Drainnage V_1 Summary_Markup Summary

Subject: EPC ENG Review
Page Index: 1
Date: 4/30/2020 12:55:45 PM
Author: dsdrice
Color: ■
Layer:
Space:
Page Label: 1

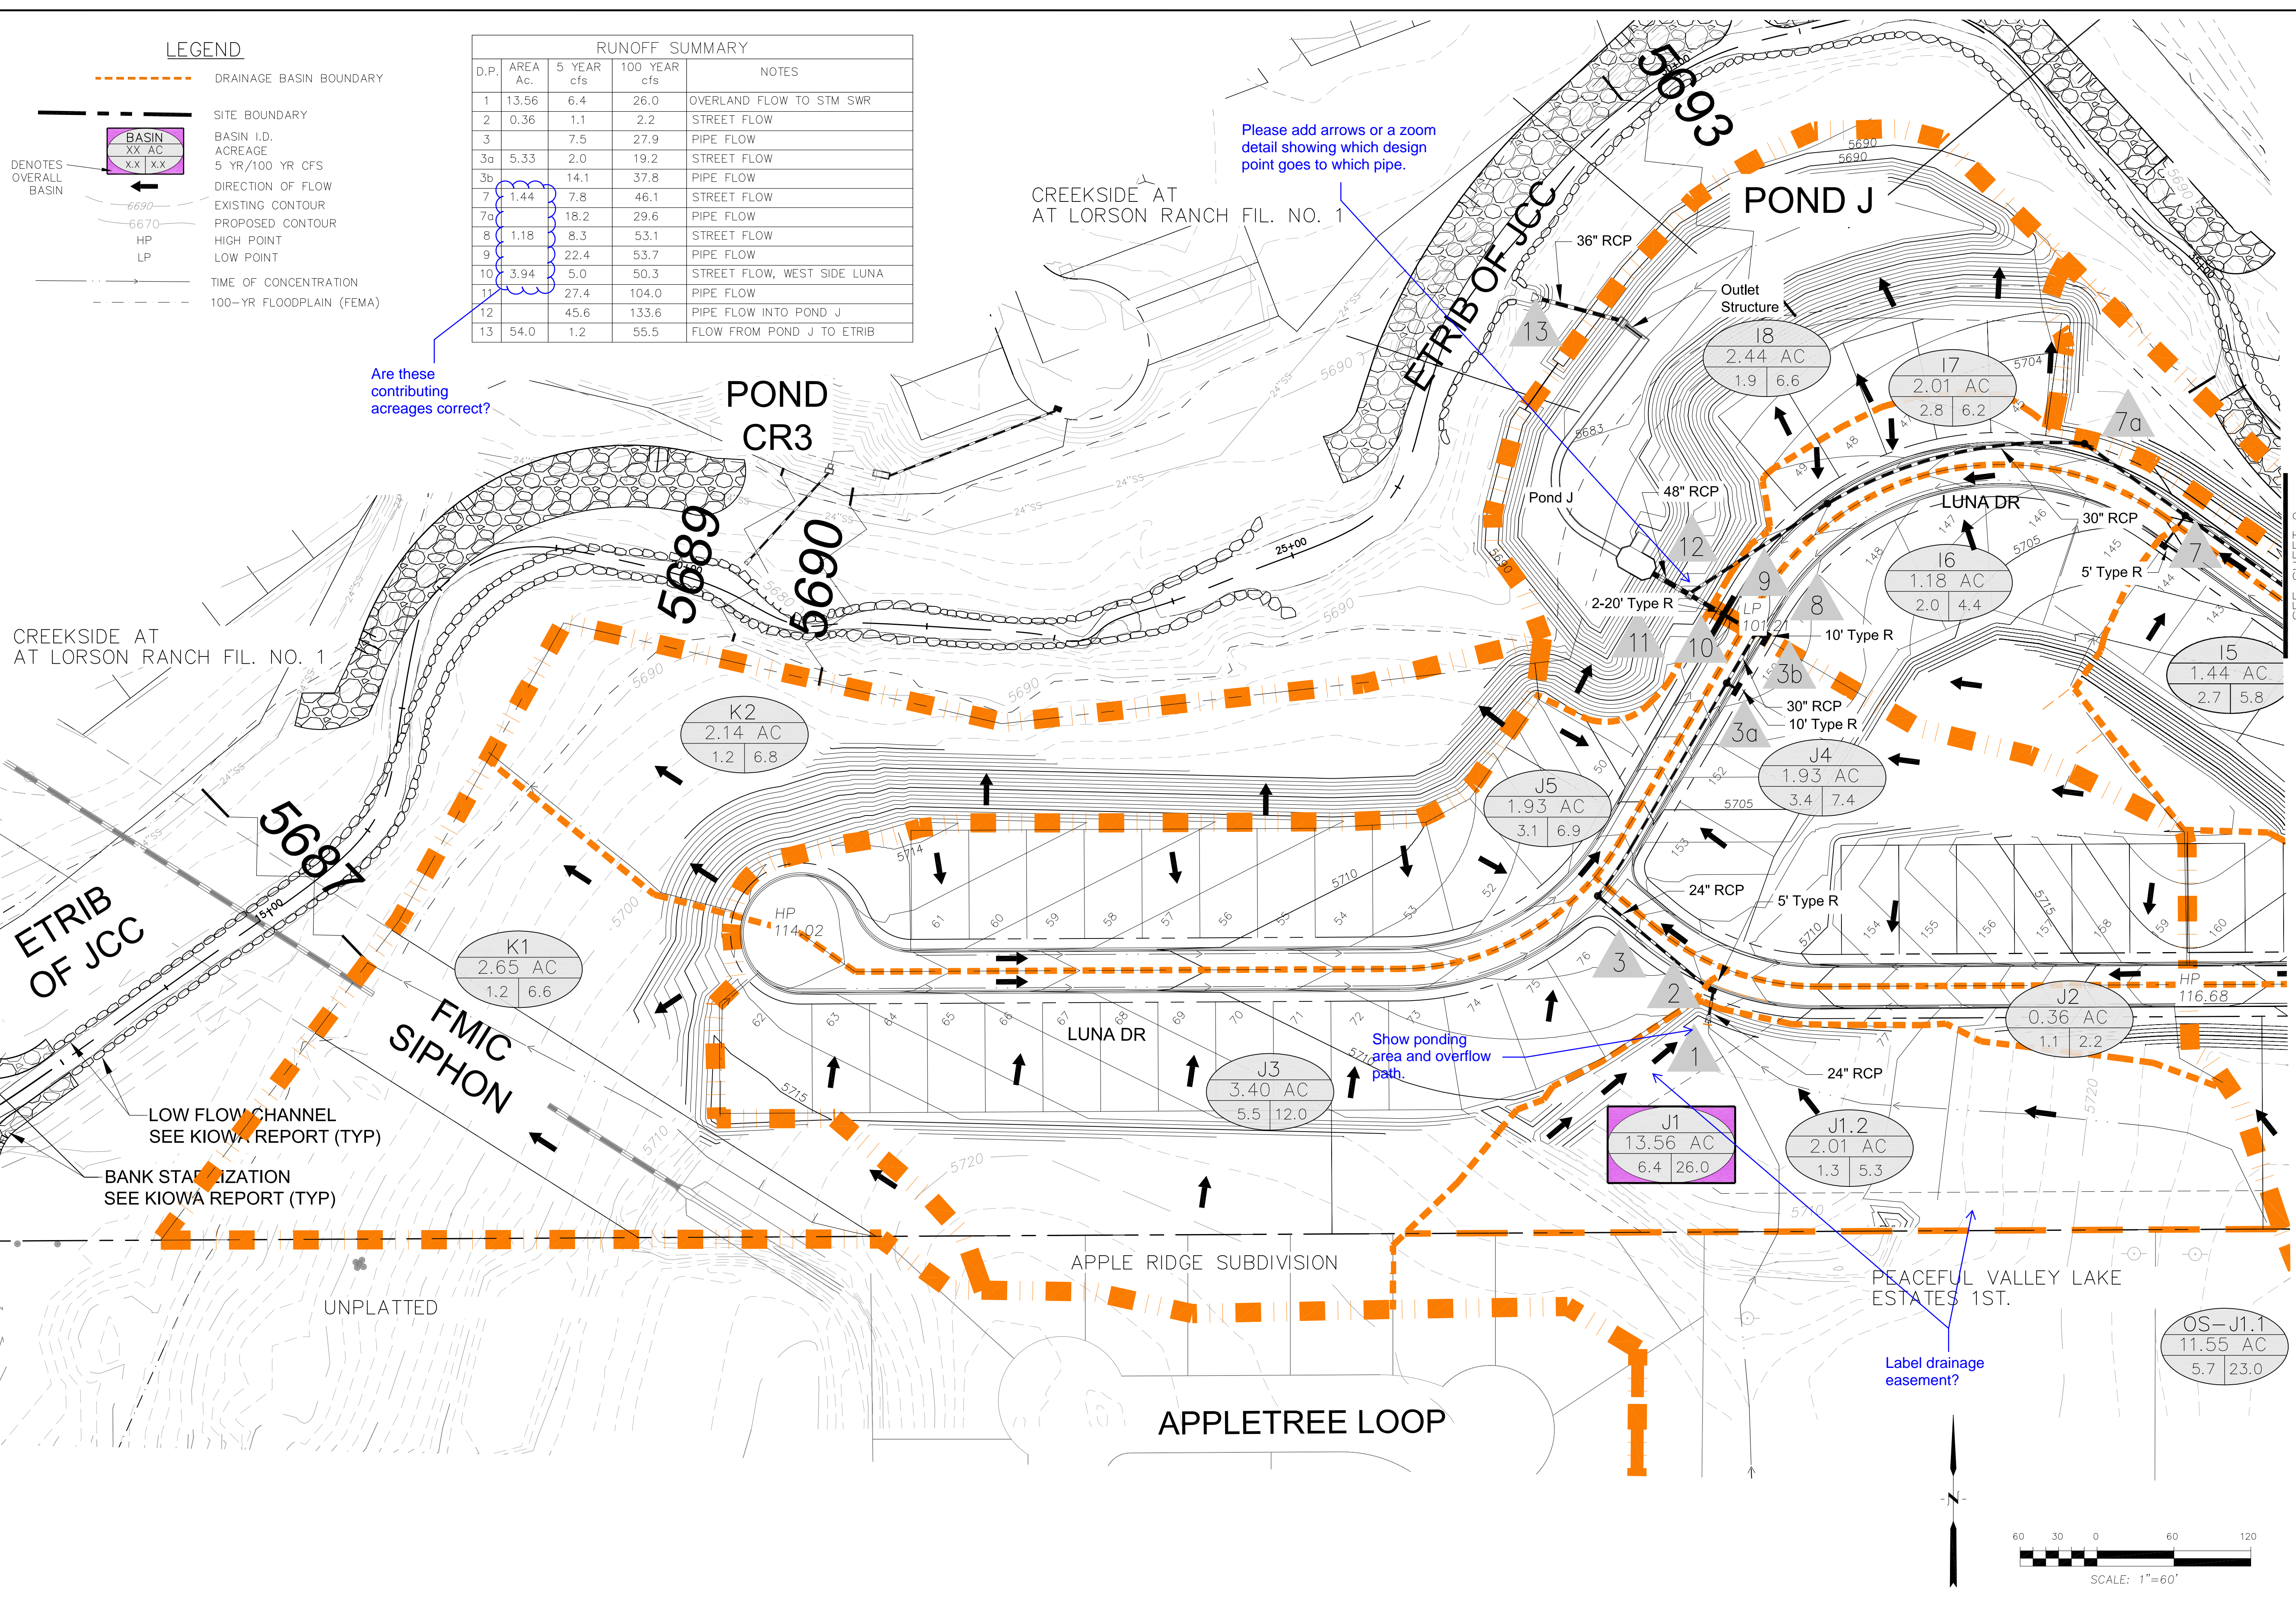
Please add arrows or a zoom detail showing which design point goes to which pipe.

Are these contributing acreages correct?

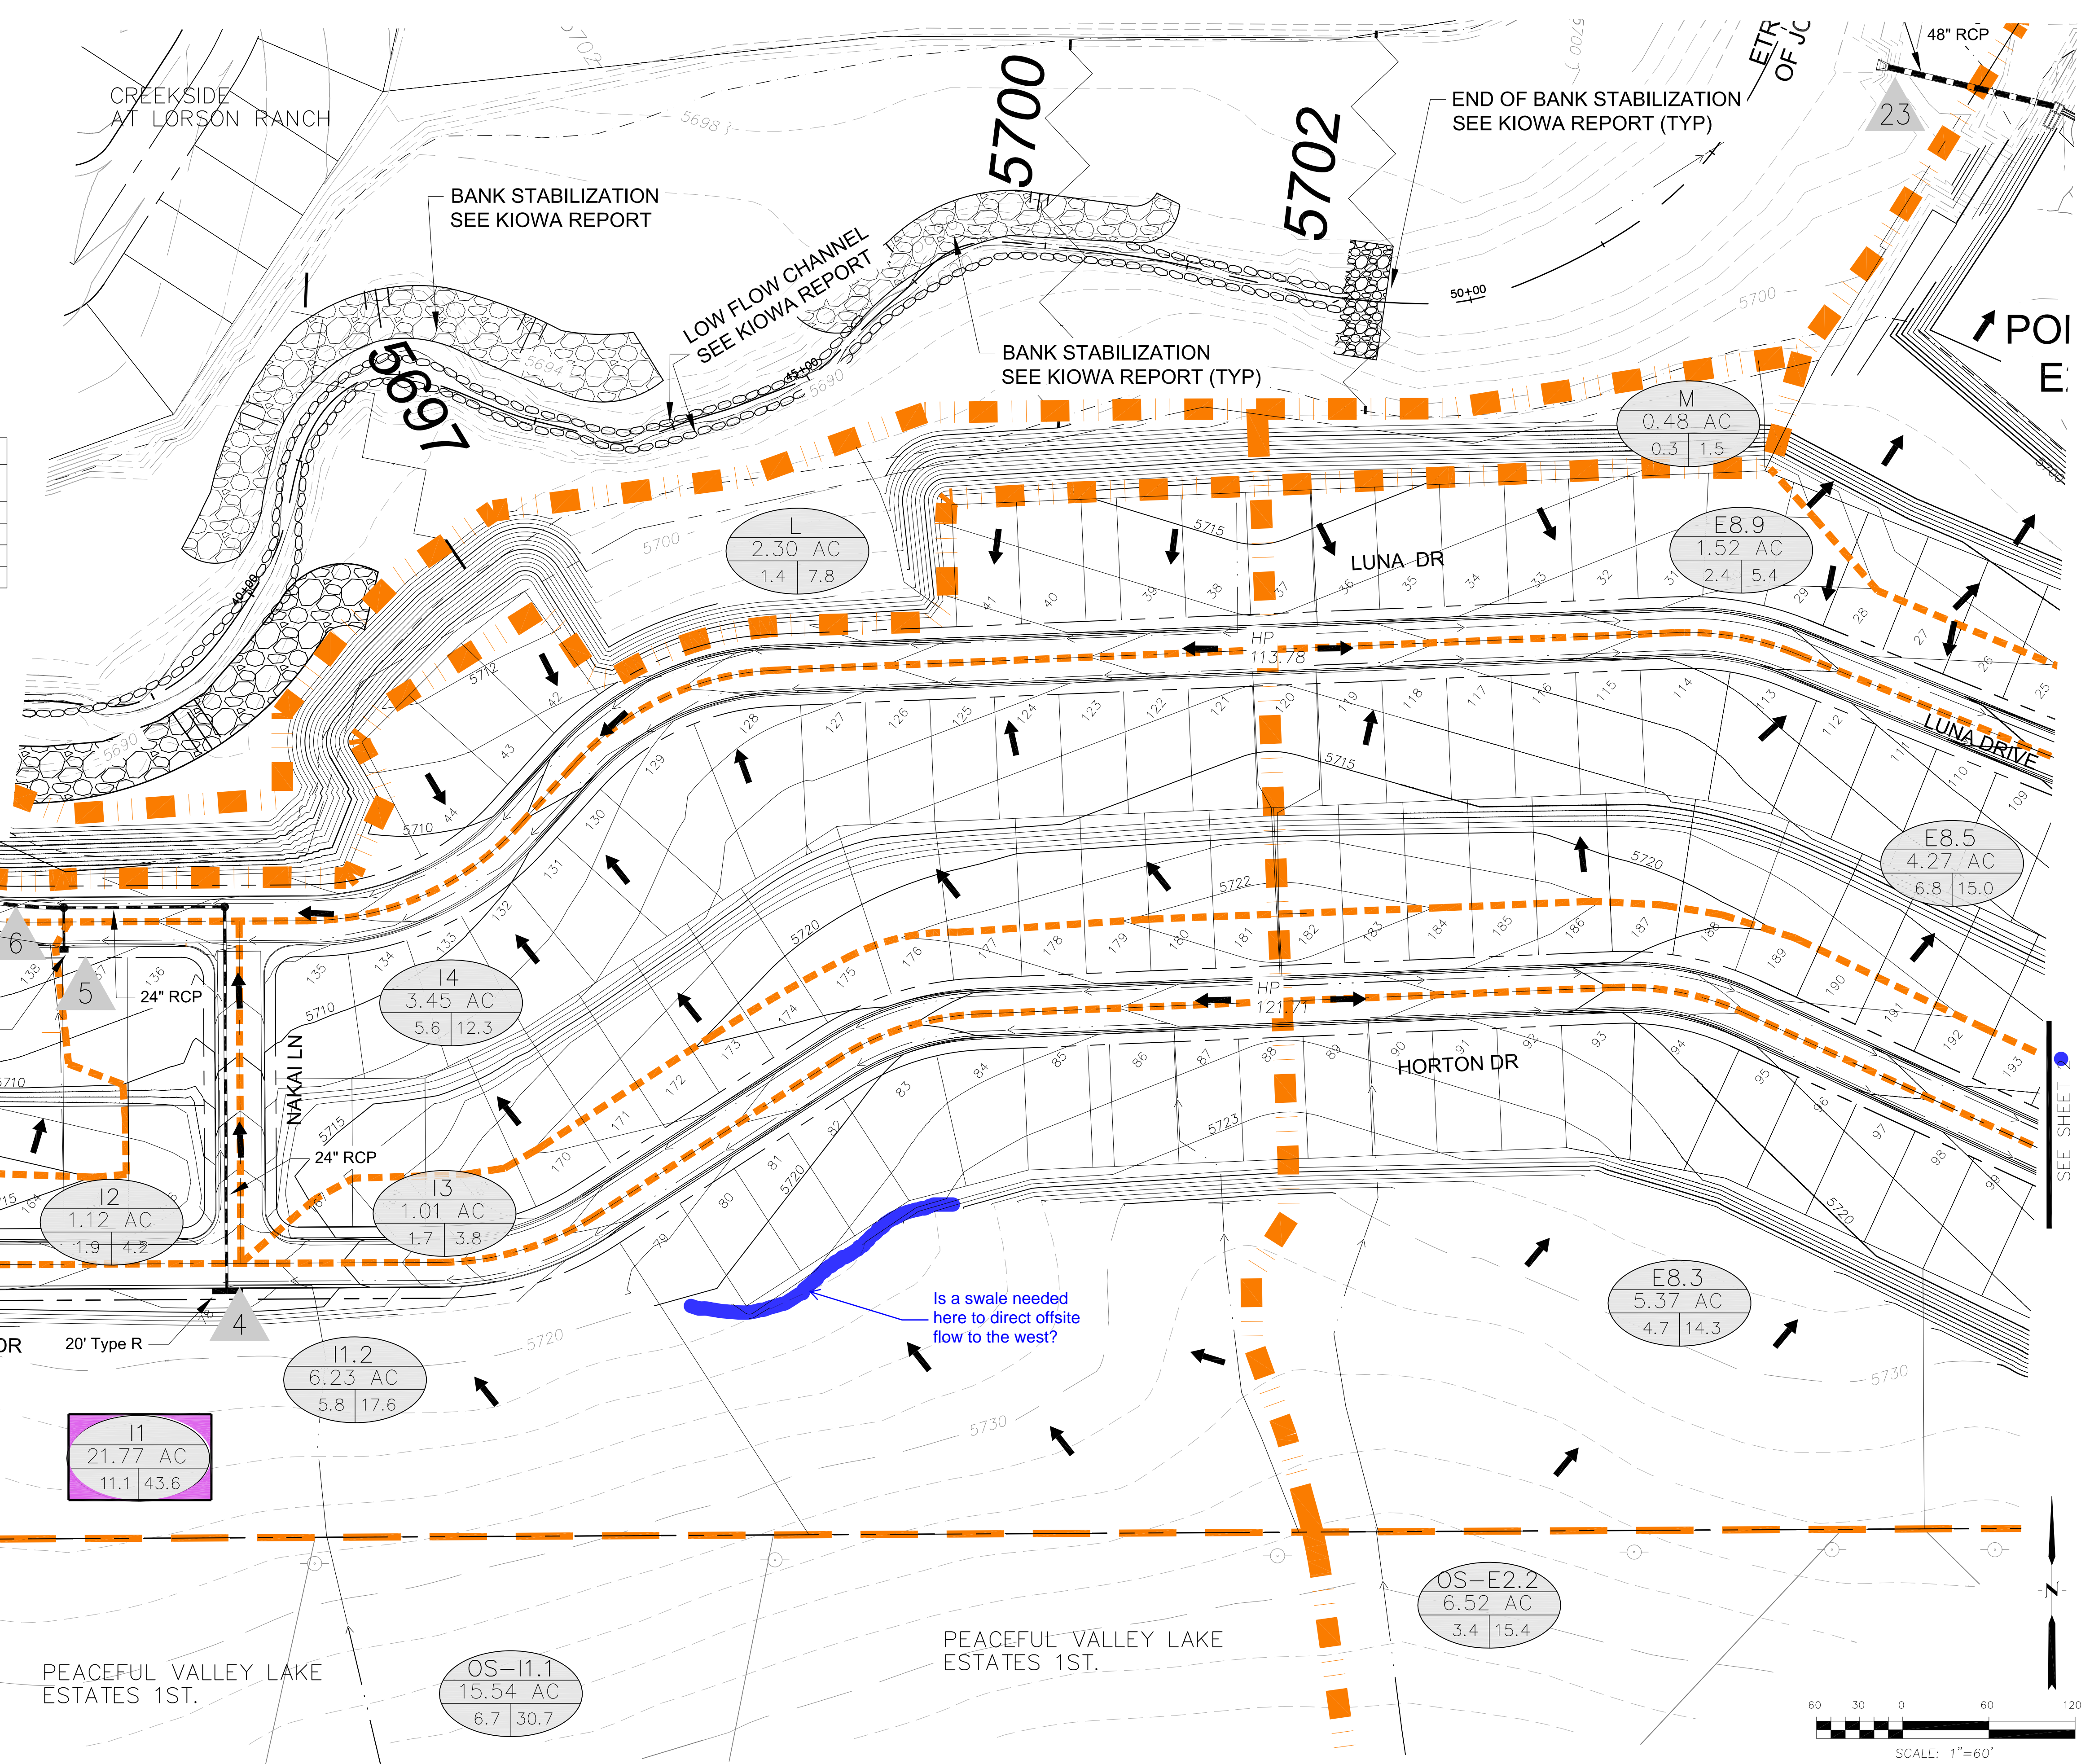
Show the access road contours or note.

Please provide DP and flows entering from LRE4 or otherwise label total combined pond inflow rates.
